CITY OF ALBUQUERQUE

March 14, 2018

**RE: Family Dollar
1400 Gibson Blvd SE
Grading Plan
Engineers Stamp Date: 3/9/18 (L15D049)**

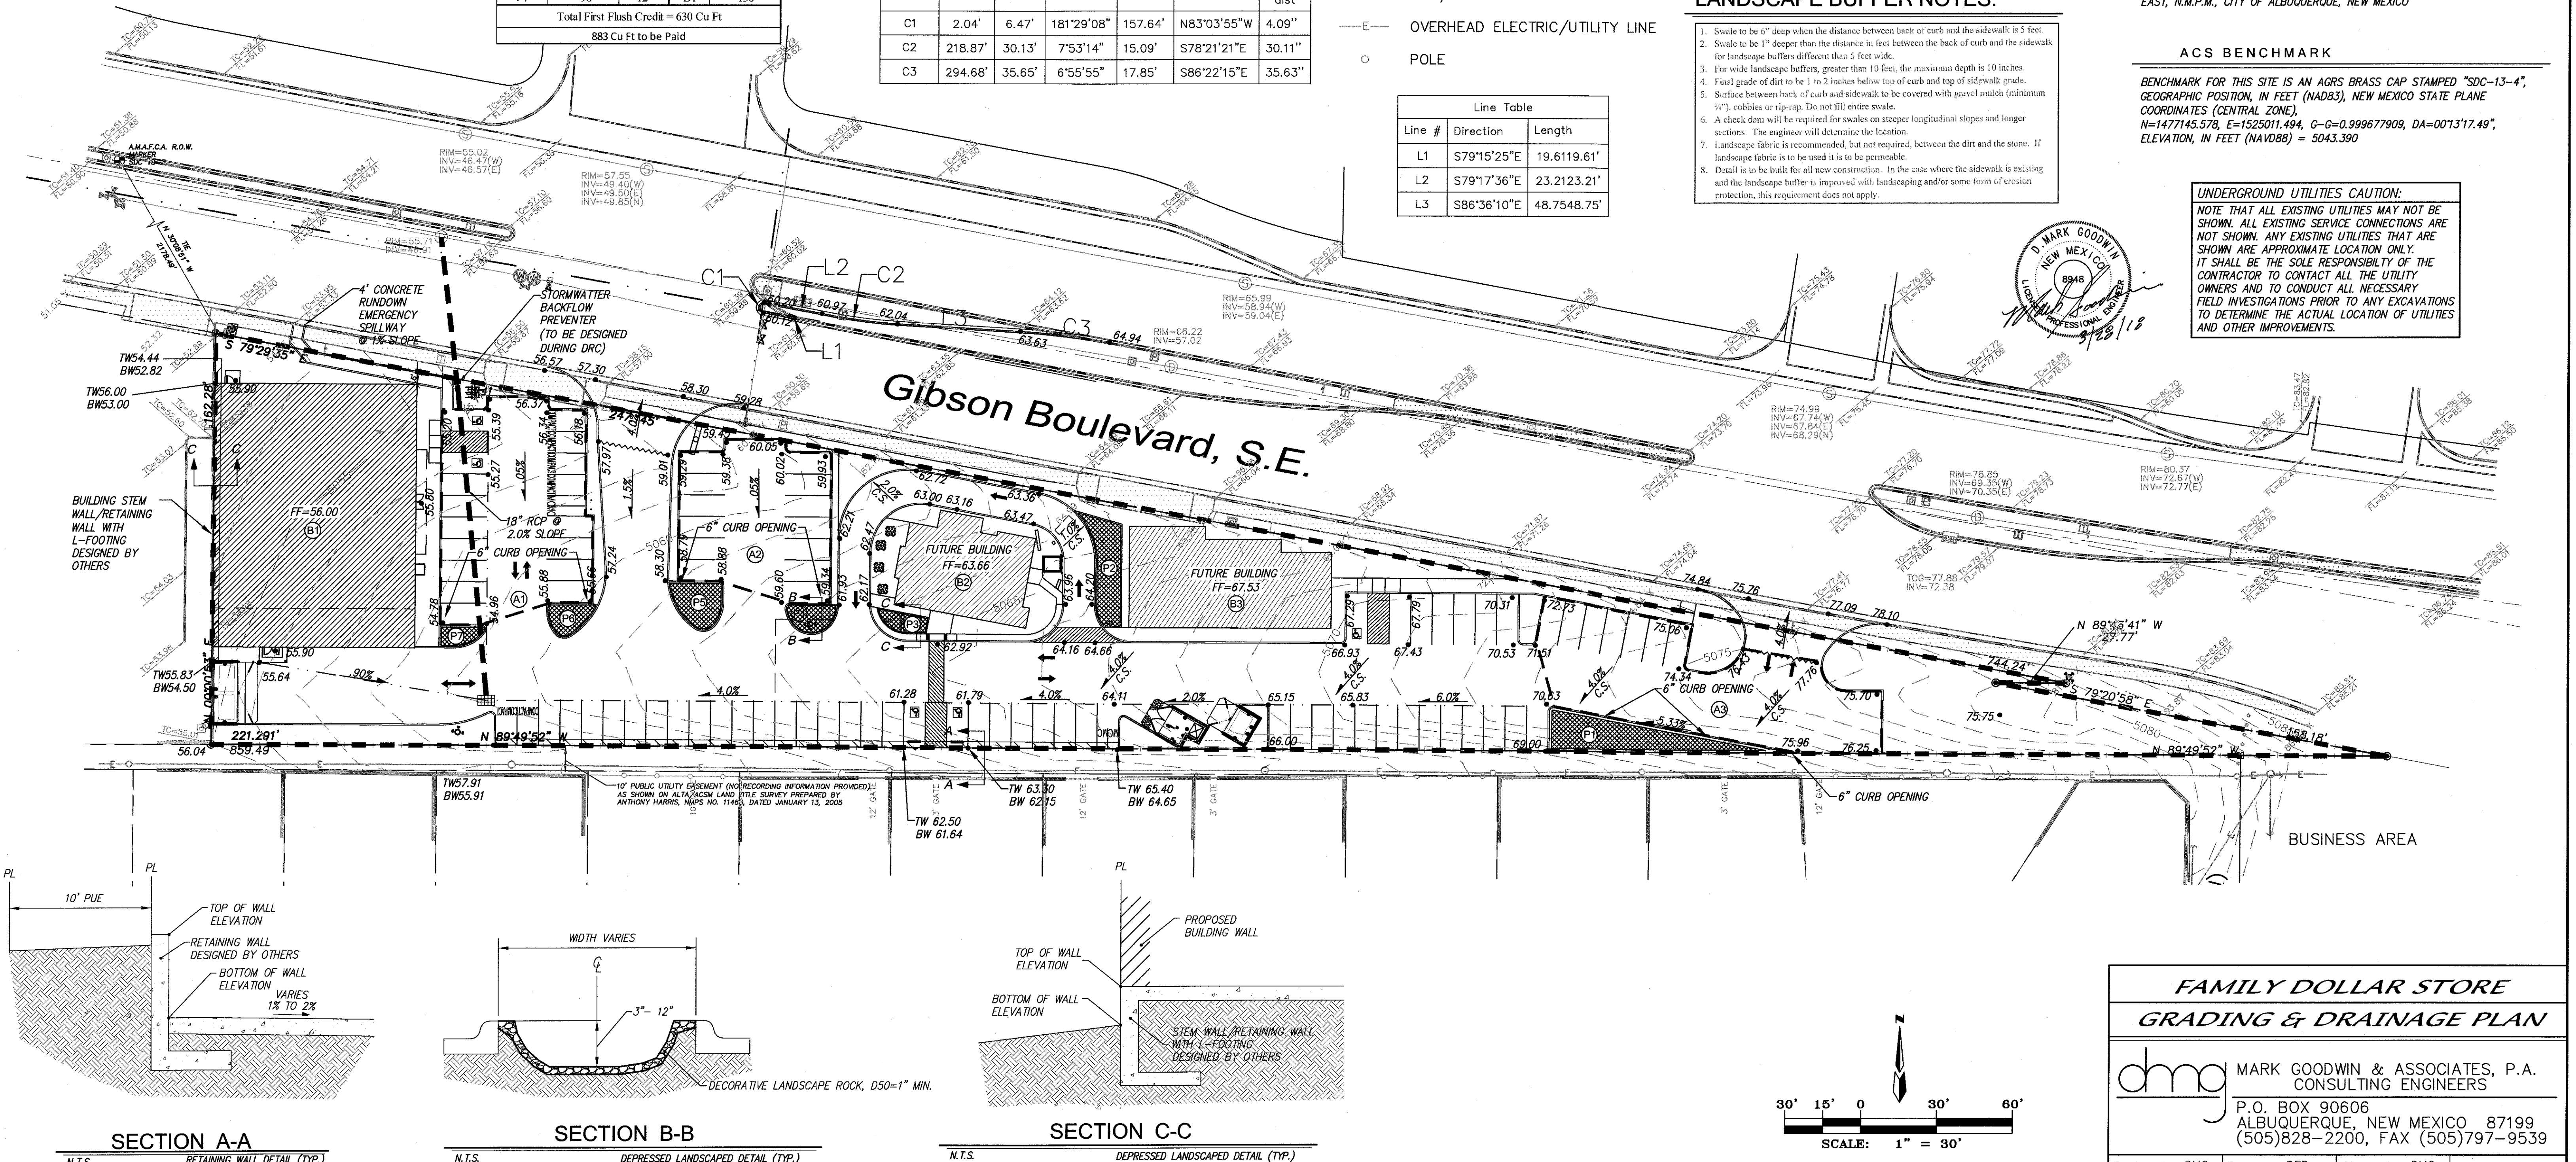
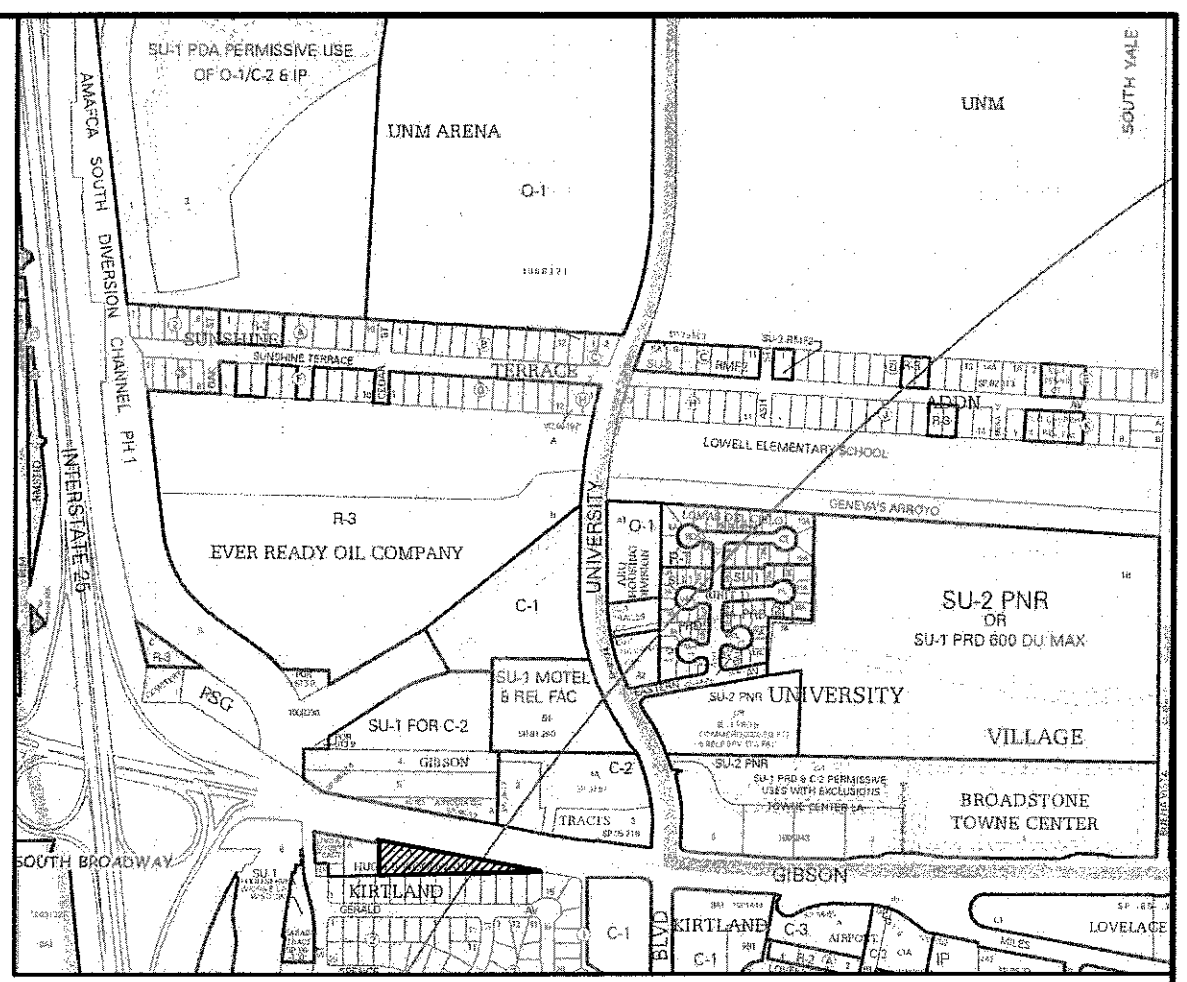
3. Stormwater quality ponds need to be located where they can intercept flows from the impervious areas. Delineate the area draining to each pond, size the pond for the area draining to it, and quantify the first flush volume that bypasses each pond. Payment of Fee-in-Lieu will then be required for the bypass volume at a rate of \$8/cubic foot.

4. Only show phase 1 construction on this plan. Delete or screen back anything to be built in phase 2. This division was partially defined on the previous plan but was removed in this plan.

6. Provide section cuts through the western property line. It appears a new retaining wall is proposed here that will be different from A-A. This will need to demonstrate that no encroachments are being made onto the adjoining property as well. Show existing and proposed grades, the existing walls, property and PUE lines, horizontal and vertical dimensions, including dimensions to property/PUE lines.

7. What is the status of the public work order? Add a note on this plan to the effect of "No work allowed in the public right of way without an approved work order" or similar.
8. The stormwater quality ponds will need private facility drainage covenants.

2. Per the accepted grading plan dated June 15, 2006, the existing 54" storm drain in Gibson was sized to allow fully developed flows from this site.
3. Due to the layout storm water quality ponds could only be obtained in limited portions of the site to address runoff from partial of the roads and buildings. The owners have elected to do a pay in leu to be determined.

4. All the paving is being built with this grading plan for the project. Phase 2 will only incorporate the building pads for the future buildings 2 and 3.

## SECTION A-A

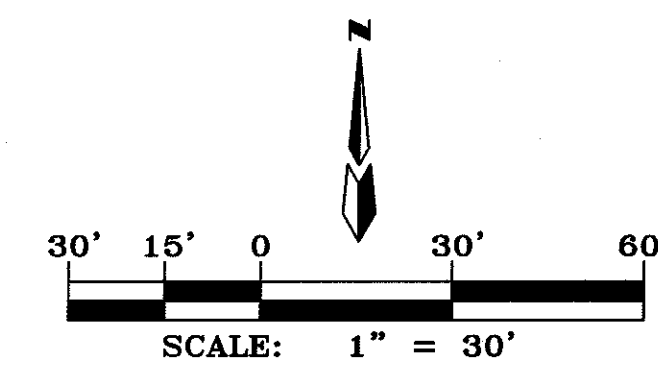
5. Work along the southern boundary needs to be clarified. Extend the section view to show existing and proposed grades, the existing walls, property and PUE lines, horizontal and vertical dimensions, including dimensions to property/PUE lines. If a new wall straddling the property line is required, written permission from the adjoining landowners will need to be obtained. Section A-A seems to indicate a retaining wall footer encroaching on the adjacent property.

5. Work along the southern property line will be maintained within our property only, the retaining wall will be within our site and will not straddle the property line.
